Addendum No. 1

RE: Contract ID C202729

Catawba County (B-4456)

Bridge Over I-40 and Approaches On NC-16

MSE RETAINING WALL					
REVISIONS					
NO.	BY	DATE	NO.	BY	DATE
1	-	-	3	-	-
2	-	-	4	-	-
					SHEET NO. W-2 TOTAL SHEETS 4

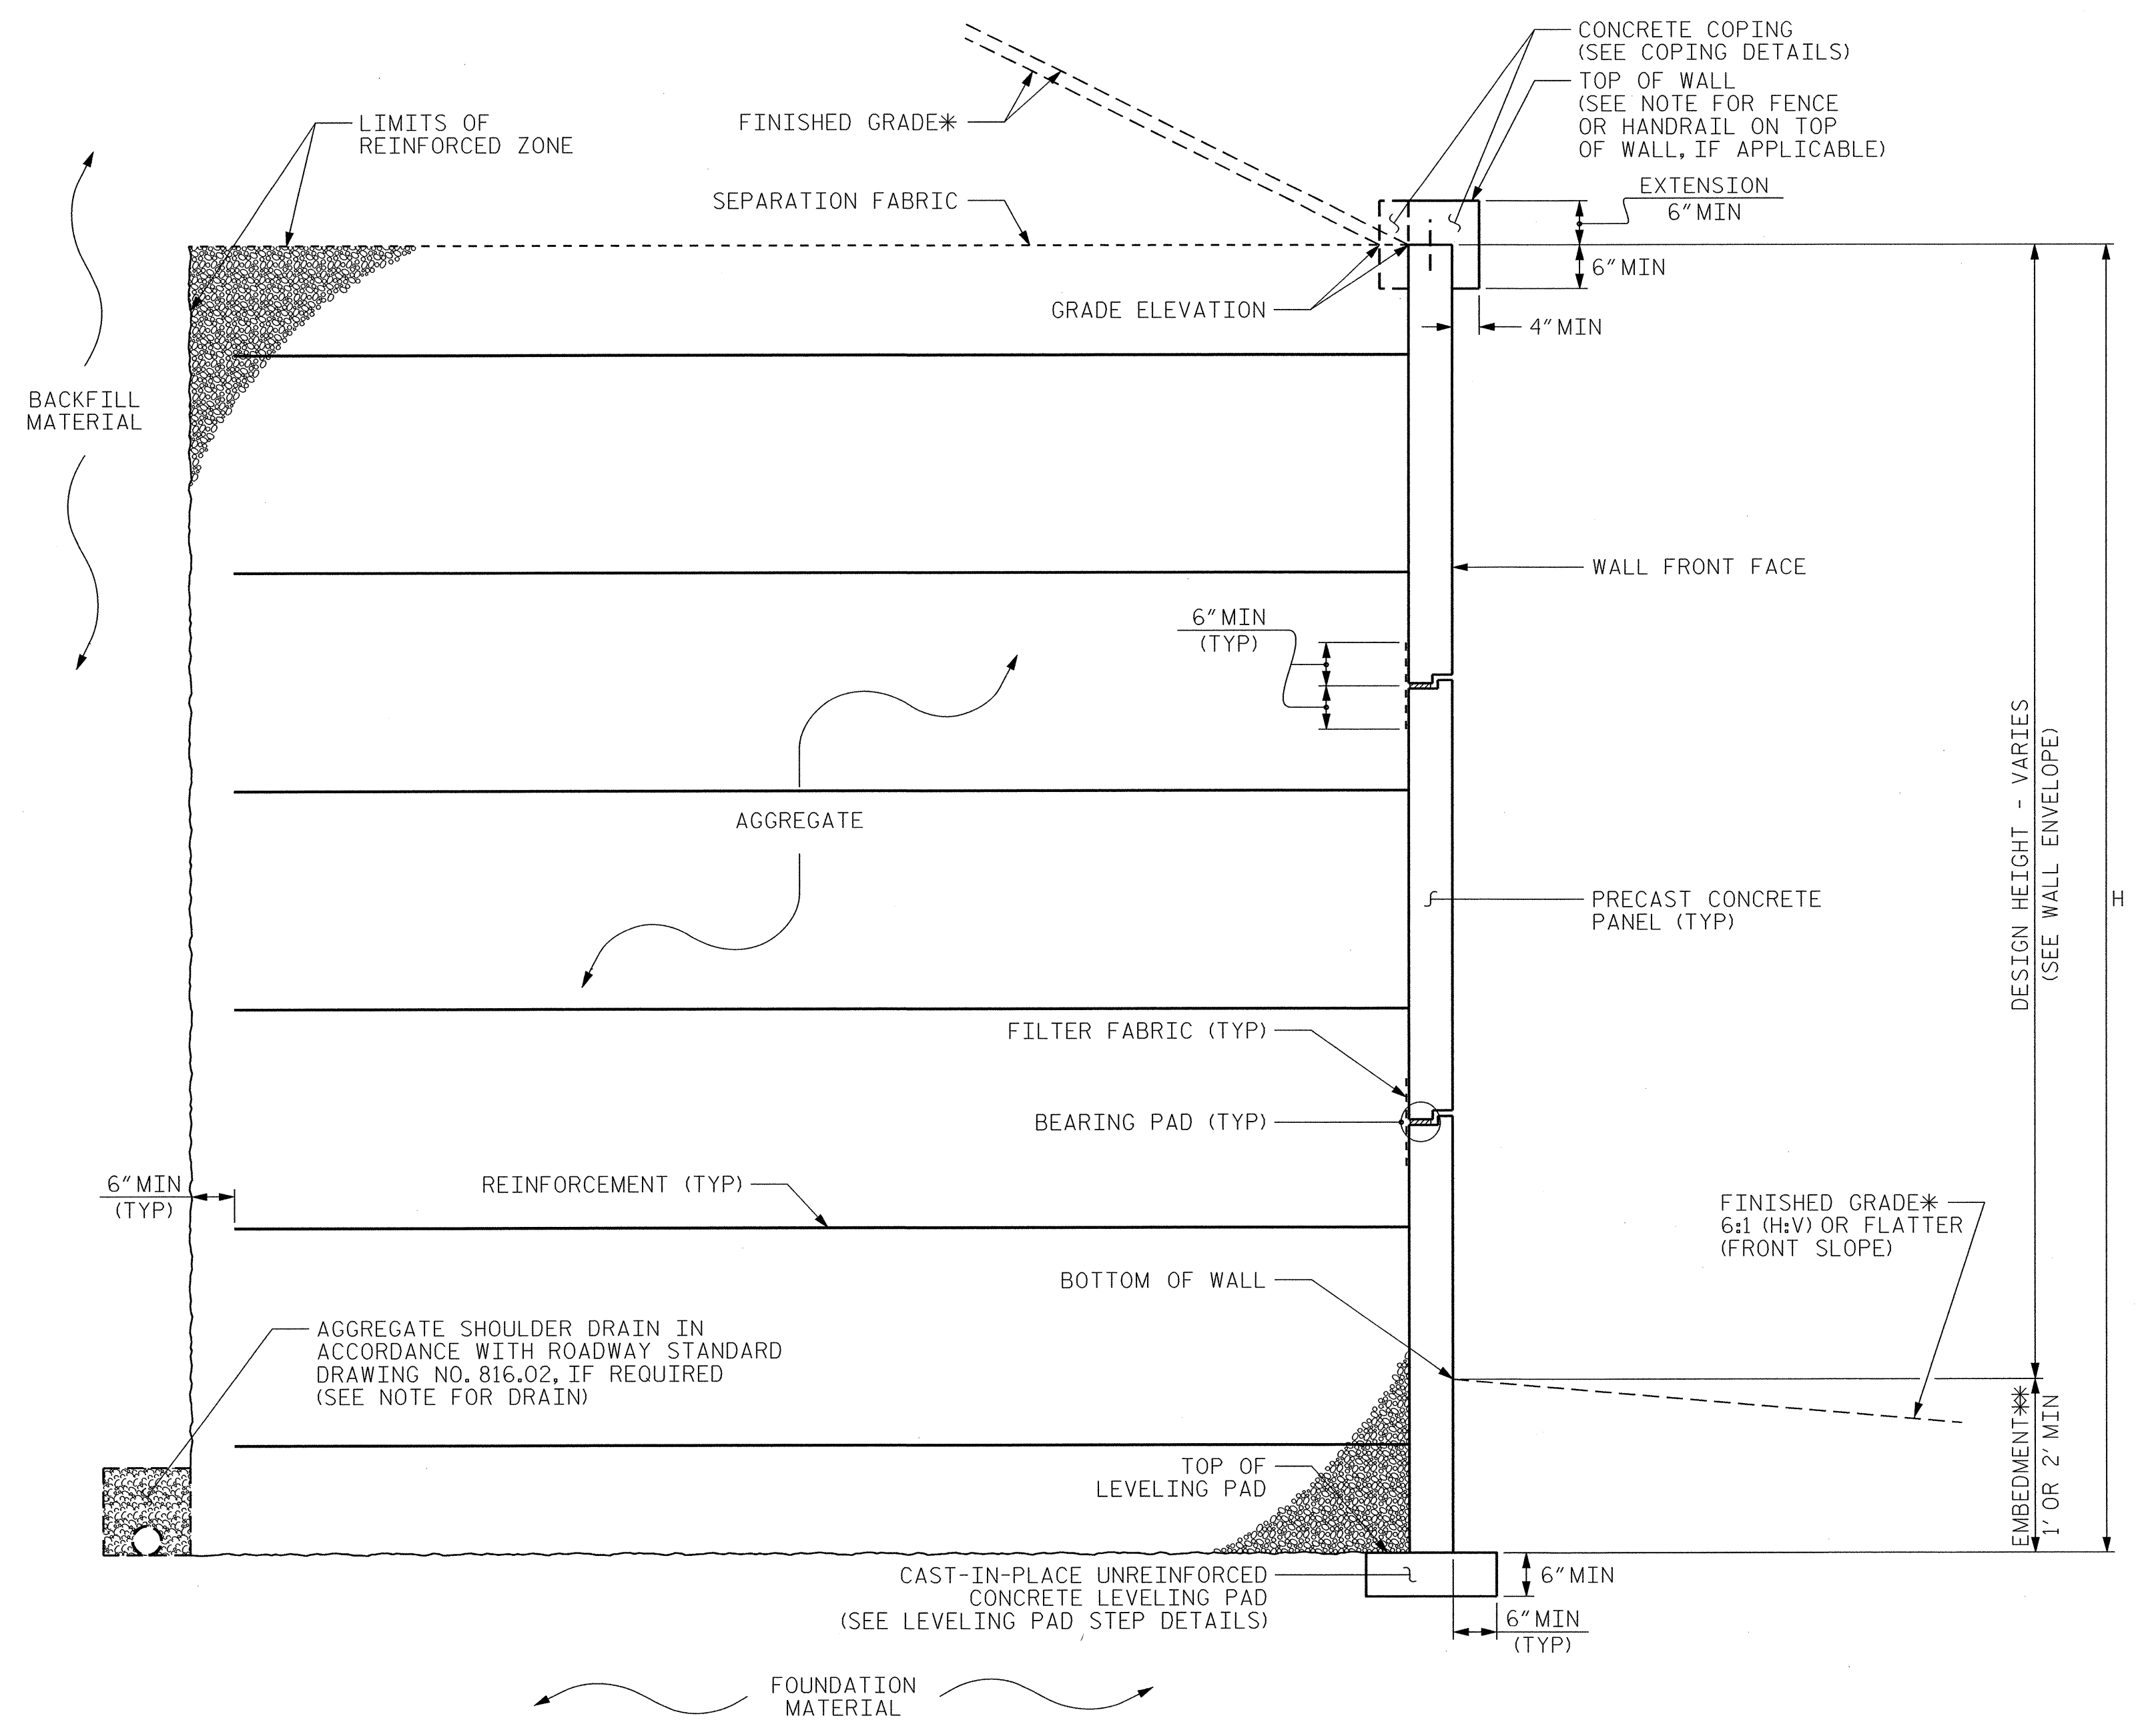
On Sheet Nos. W-2 and W-3 a detail was added. Please void Sheet Nos. W-2 and W-3 in your plans and staple the revised Sheet Nos. W-2 and W-3 thereto. On Sheet No. W-4 the notes were revised. Please void Sheet No. W-4 in your plans and staple the revised Sheet No. W-4 thereto.
